**ENGINEERING DIVISION**  
**Portland Department of Public Services**  
**55 Portland Street**  
**Portland, ME 04101**

**M E M O**

TO: Helen Donaldson  
FROM: Mike Farmer, Project Engineer  
DATE: Oct. 19, 2015  
Revised 10/21/2015 (Added comment 8)  
RE: 158 Fore Street (Hotel)

I am submitting the following comments, on behalf of the Engineering Division, regarding the Site Plan for the proposed AC Hotel project at 158 Fore Street. These comments are based on review of the Utility Plan (9/29/2015), Site Plan (9/29/2015), and Construction Details sheet C2.0 (9/29/2015).

**SITE PLAN**

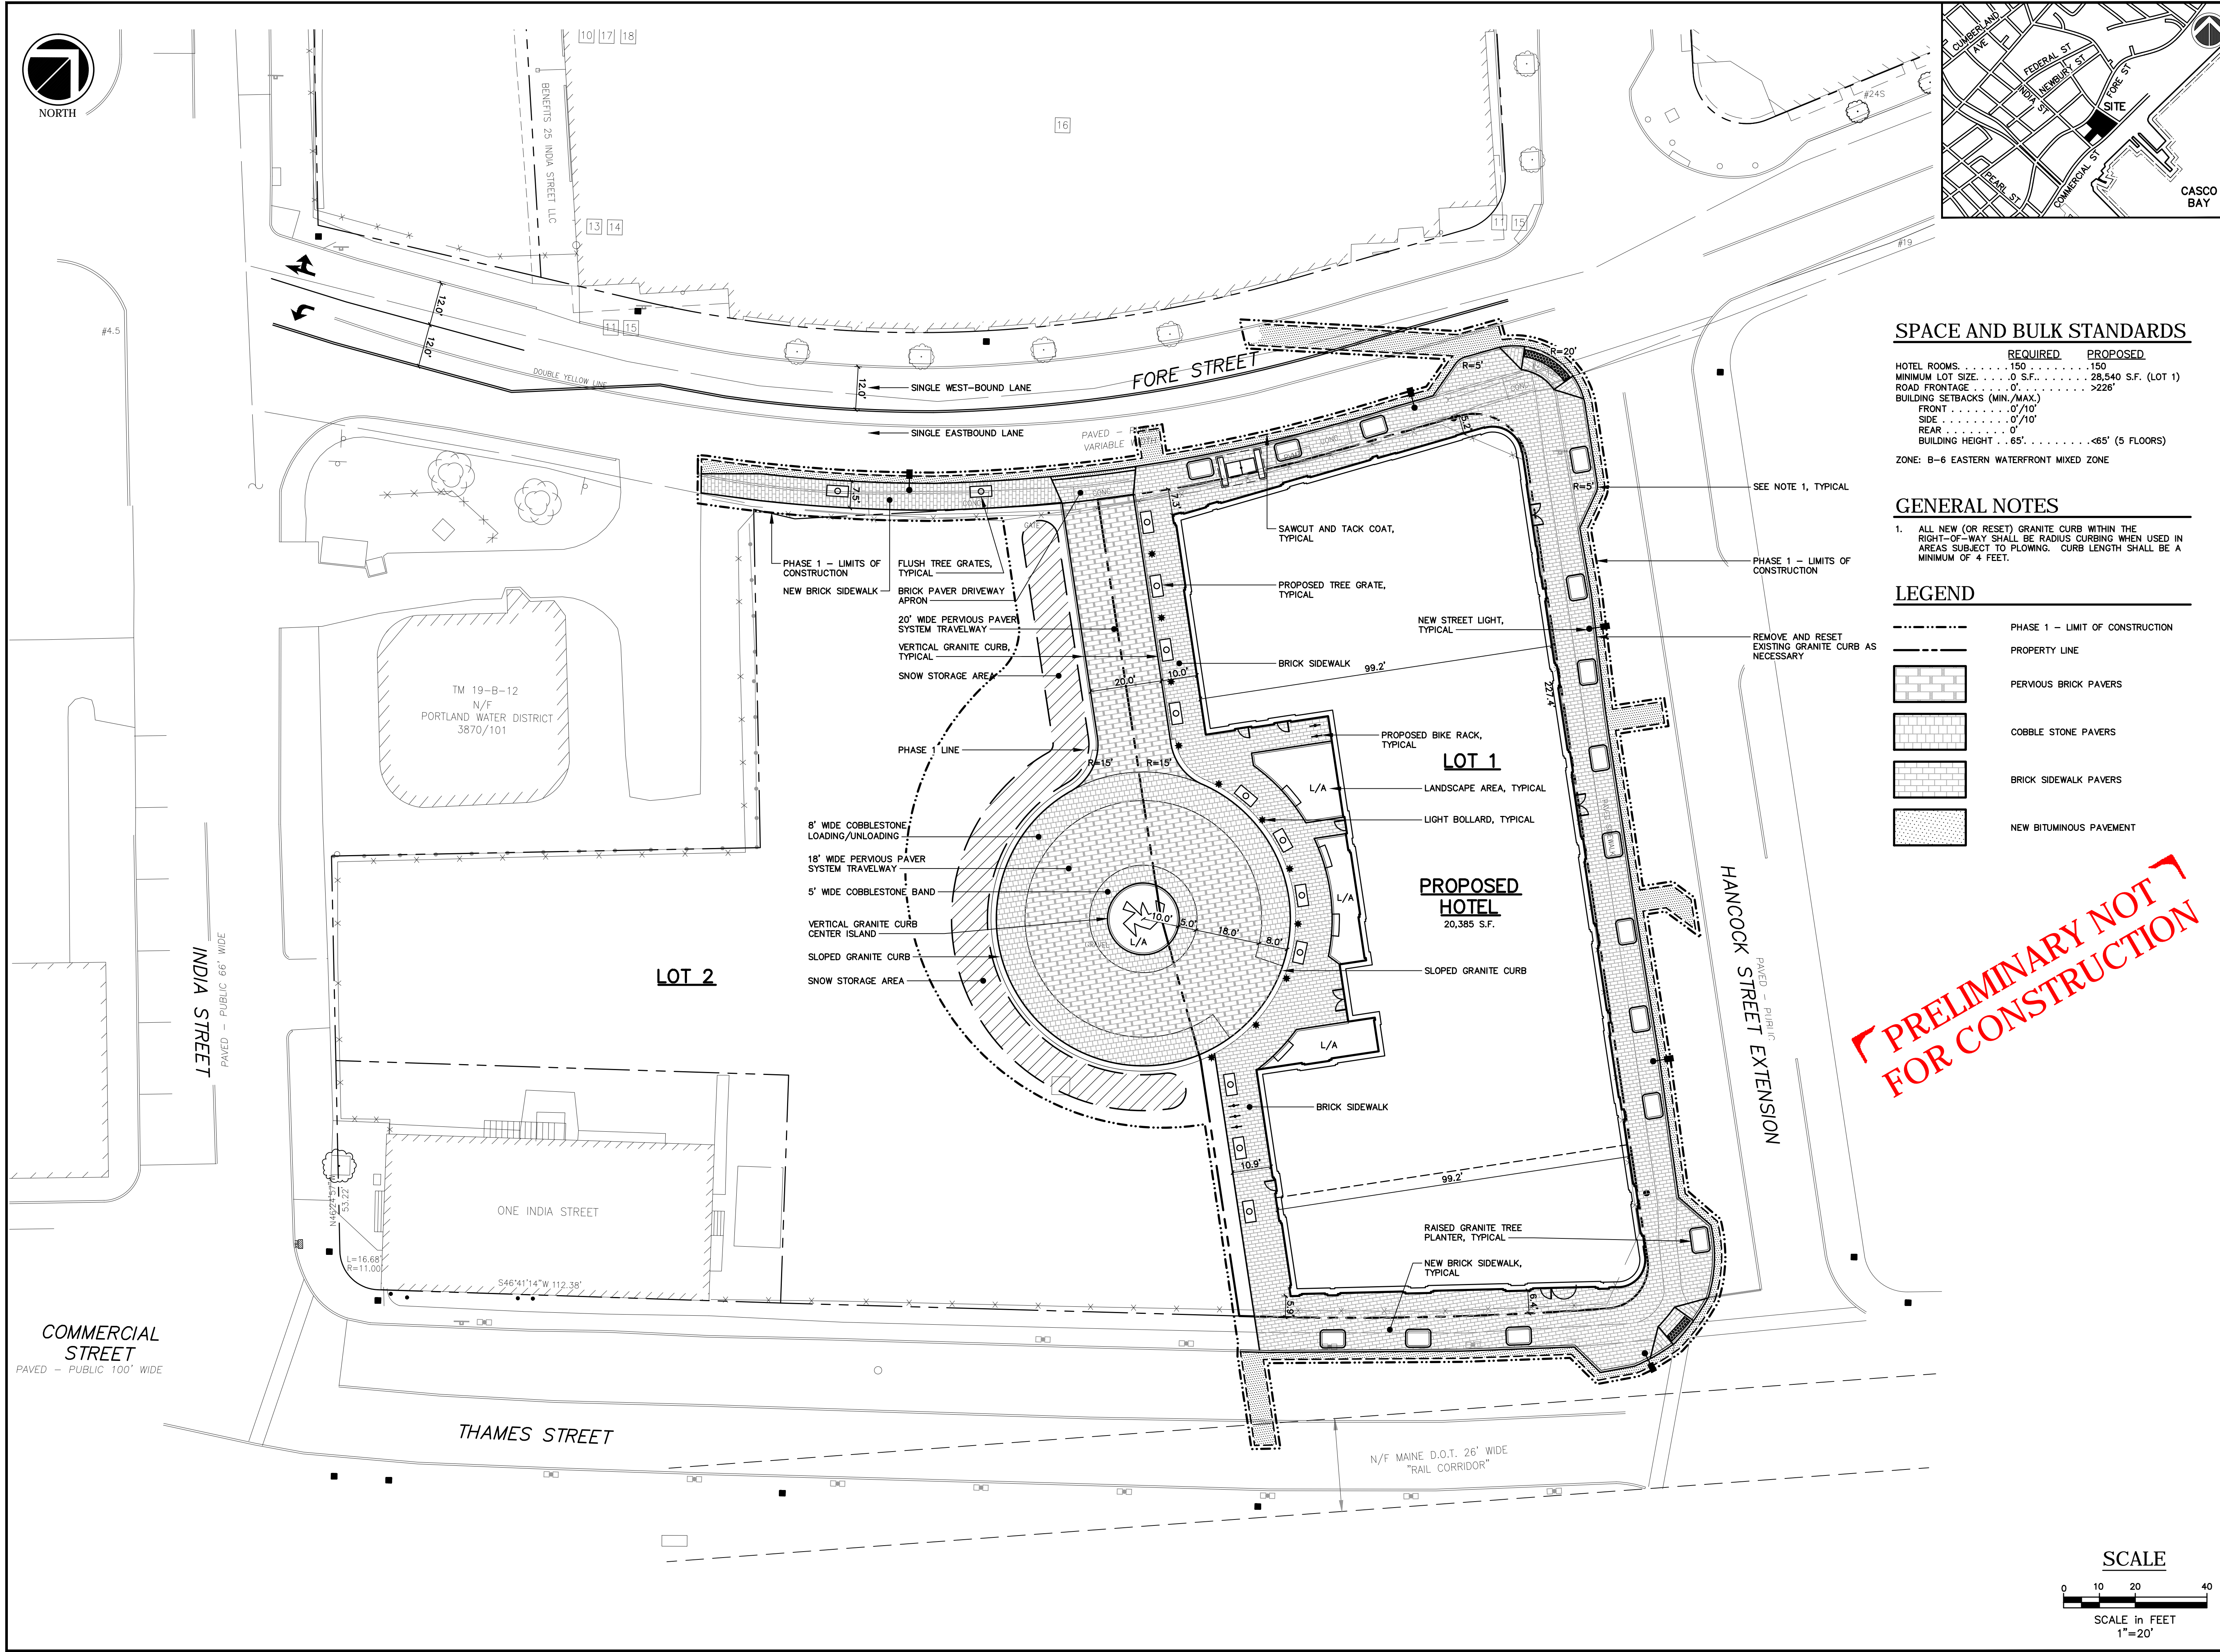
6. All new (or reset) granite curb construction should be laid out so that mitered corners are not used on curb “bump outs,” or other areas, where they are exposed to possible plow damage. Circular curb should be used in these areas in lieu of mitered corners. The curb layout should be designed so no curb pieces shorter than 4 feet are required.

7. The circular driveway plans show accessible sidewalk ramps adjacent to granite cobblestone pavement in the driveway. The granite cobblestones would look nice; but, I wonder if the cobblestone surface can be constructed smooth enough to meet ADA design standards.

UTILITY PLAN

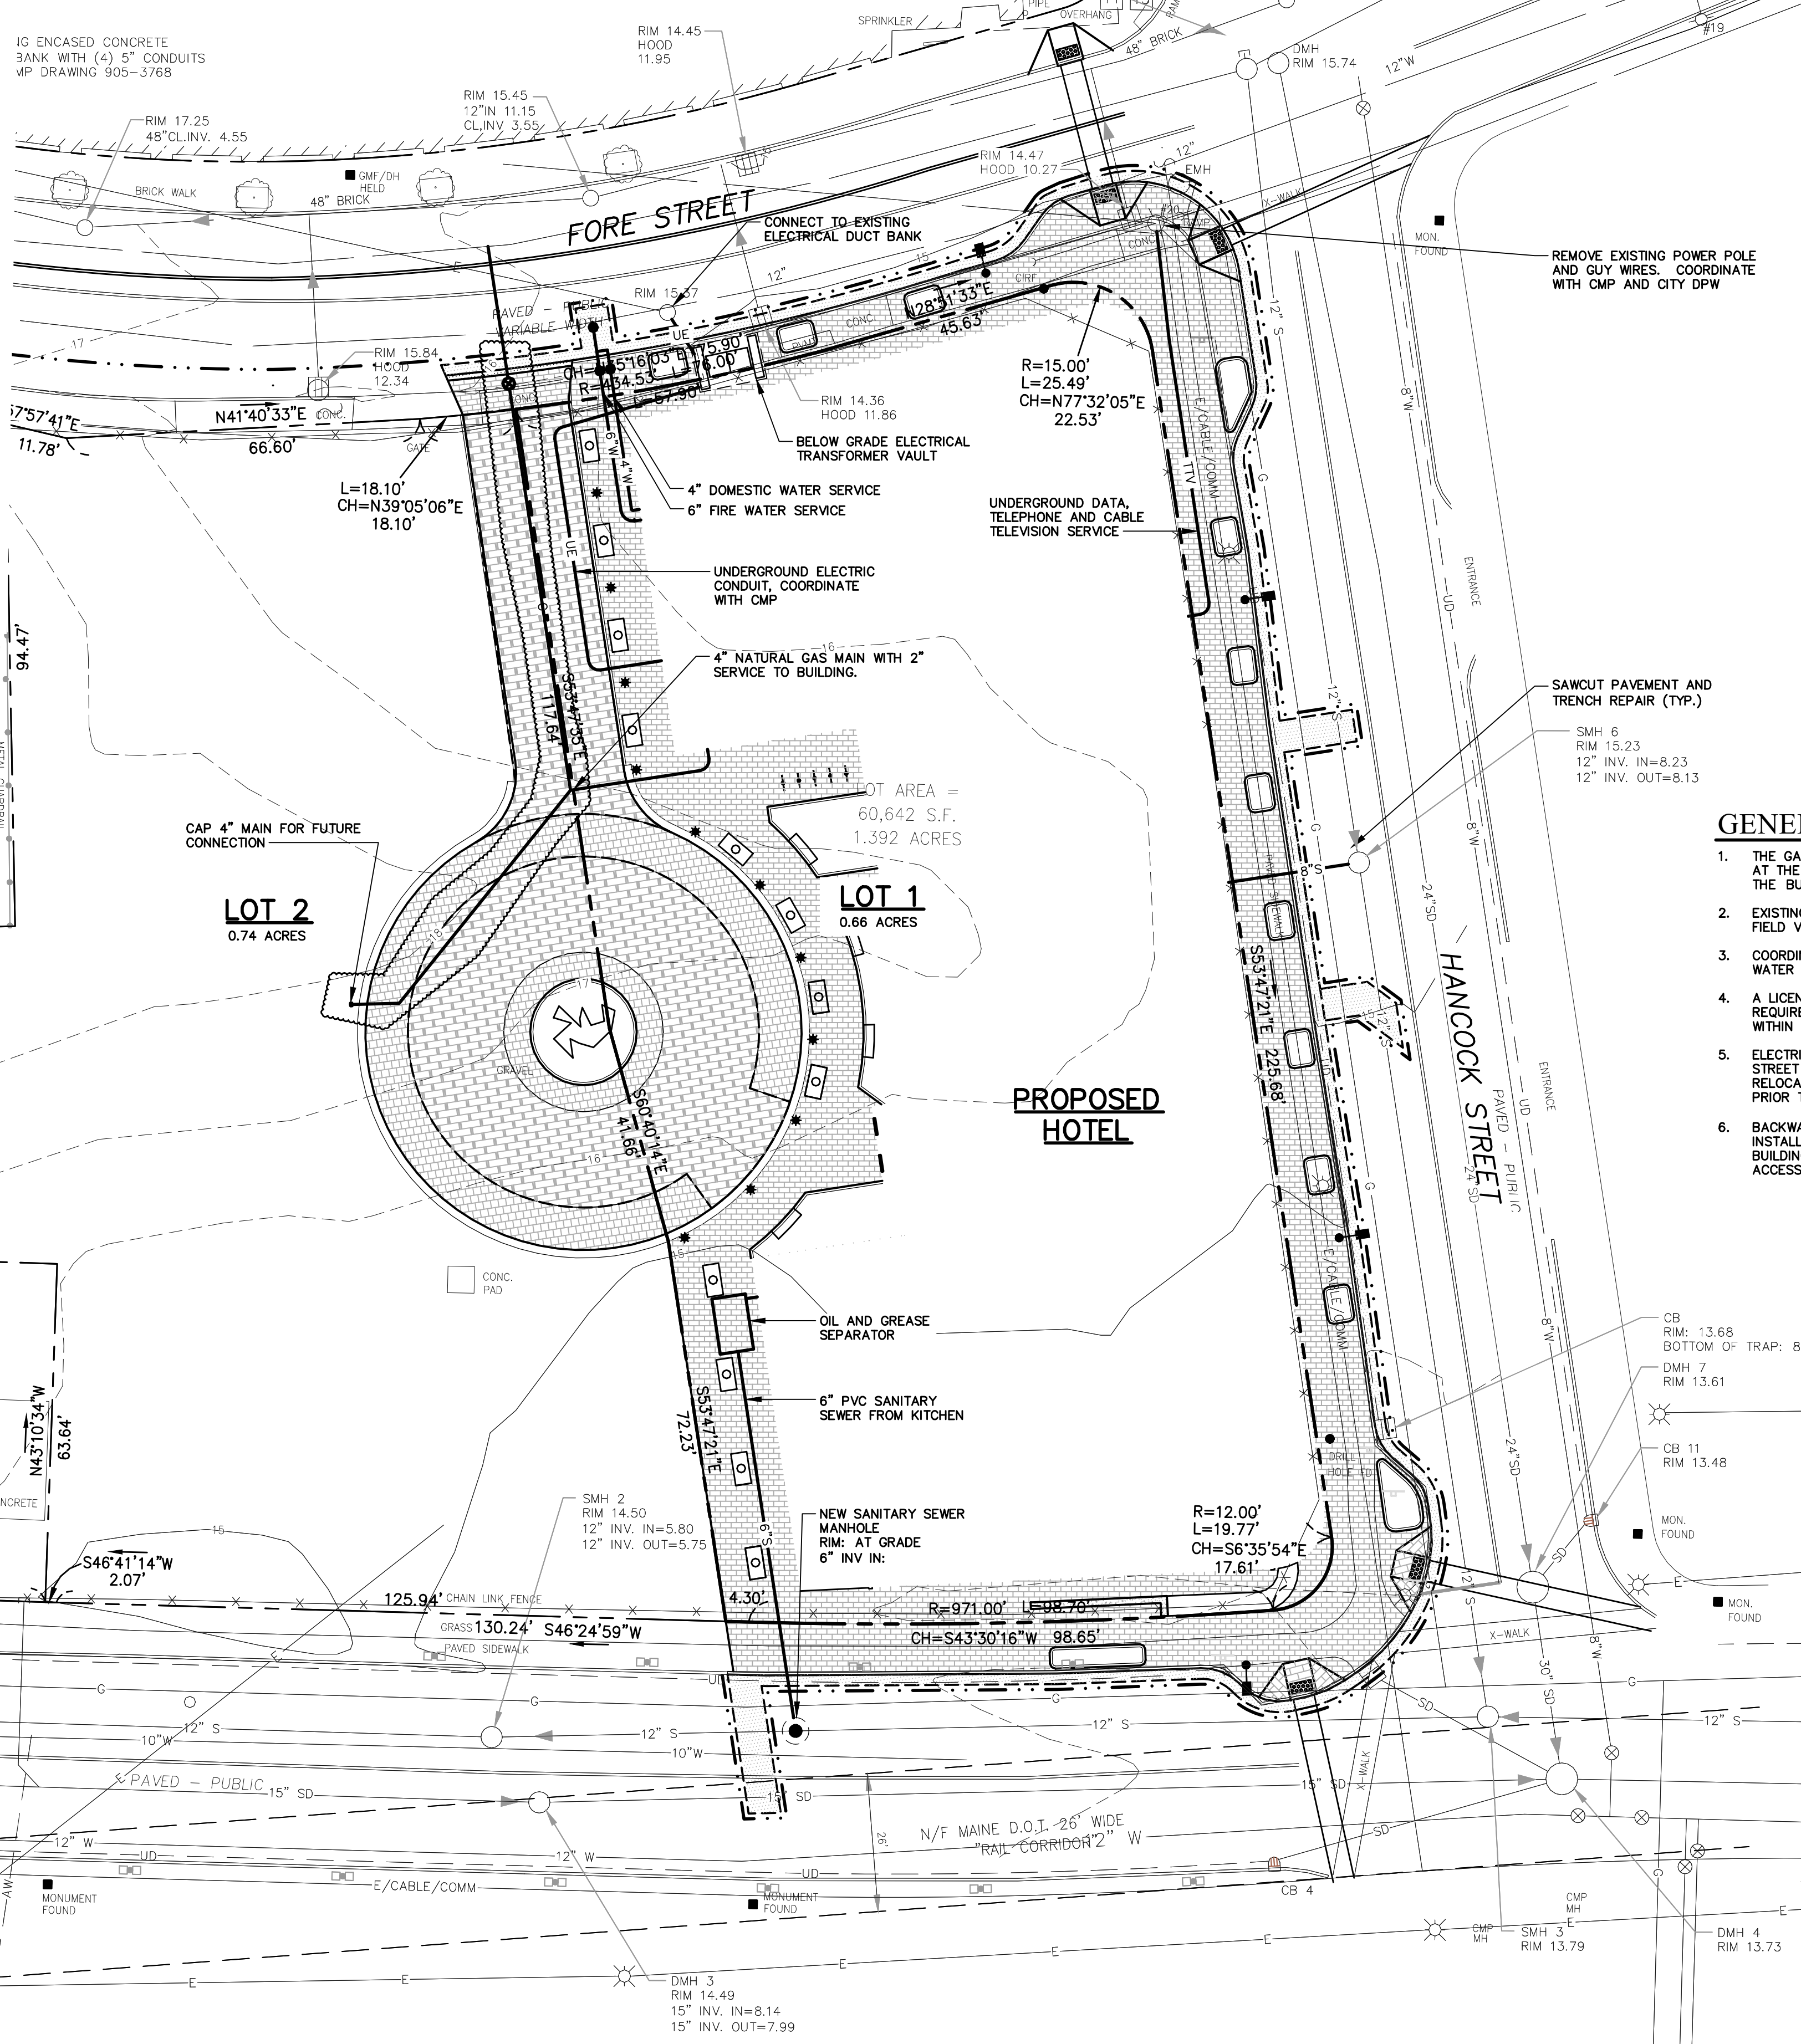
1. We recommend that the electric power supply for the project be extended from the existing underground electric power distribution system in Fore Street and other adjacent streets, not from the existing utility pole and overhead wires at the corner of Fore St. And Hancock St., as shown on the plans. The project plans should include removing the existing utility pole and overhead wires, if this can reasonably be done at a reasonable cost.

6 CONCRETE ENCASED DUCT
NOT TO SCALE

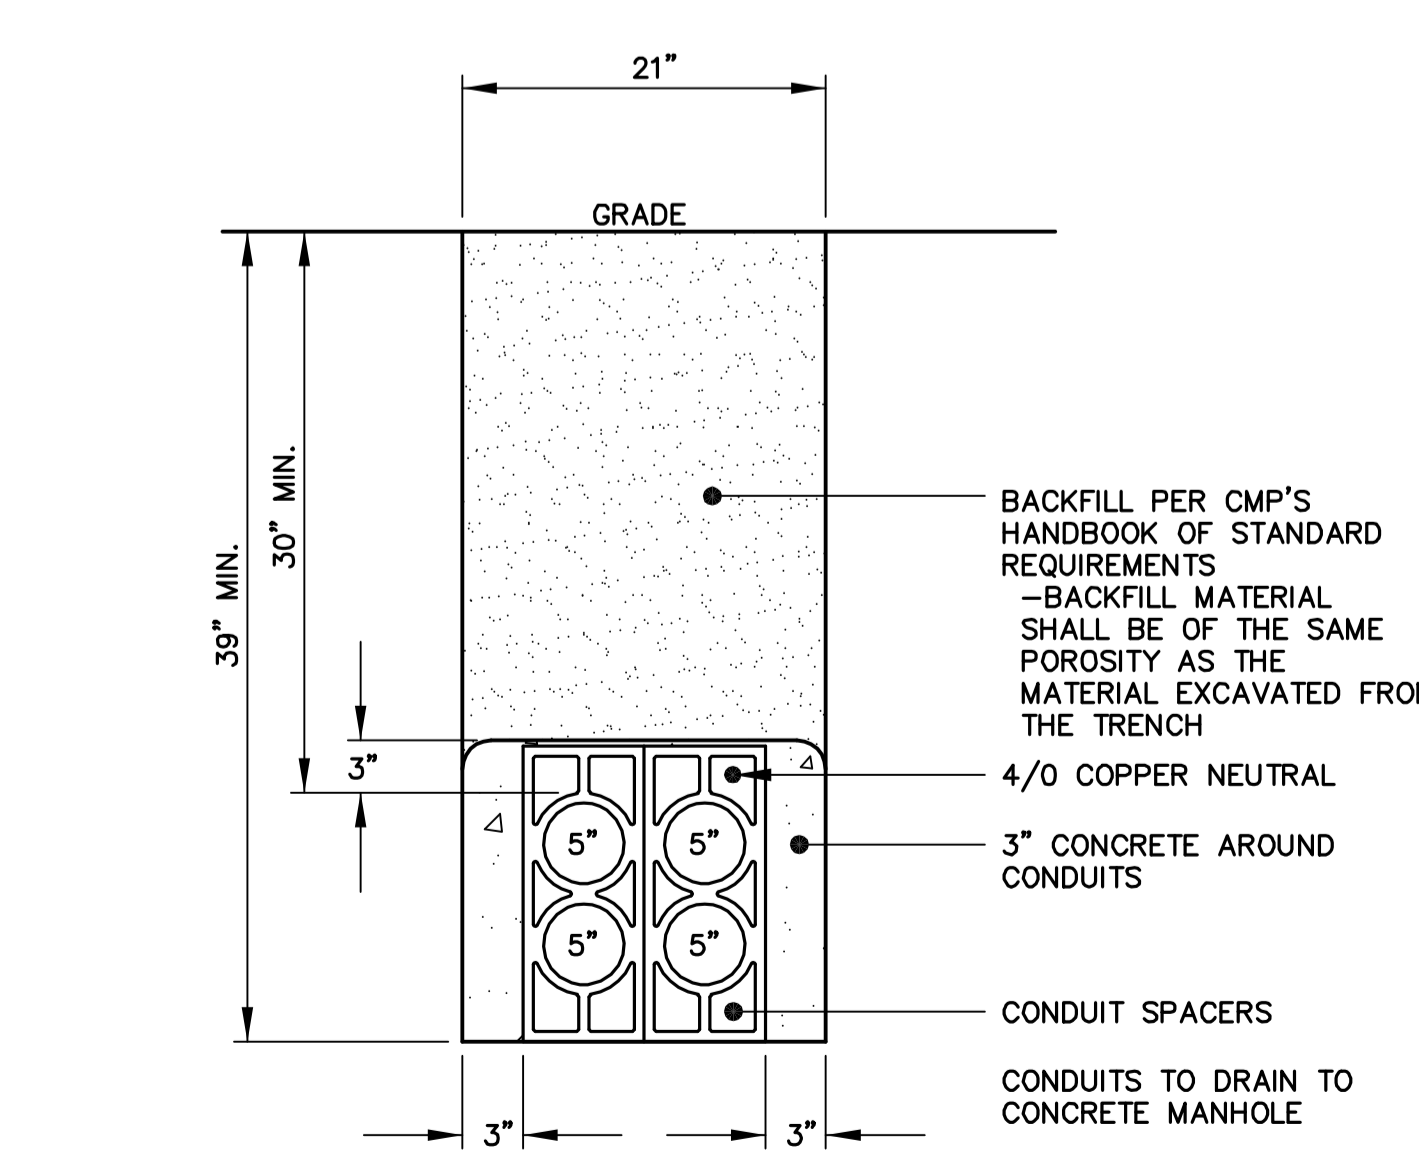
2. Underground electric power (and underground communication) conduits in the street right of way should be incorporated into concrete encased duct banks. The details on sheet C2.0 should be revised accordingly.
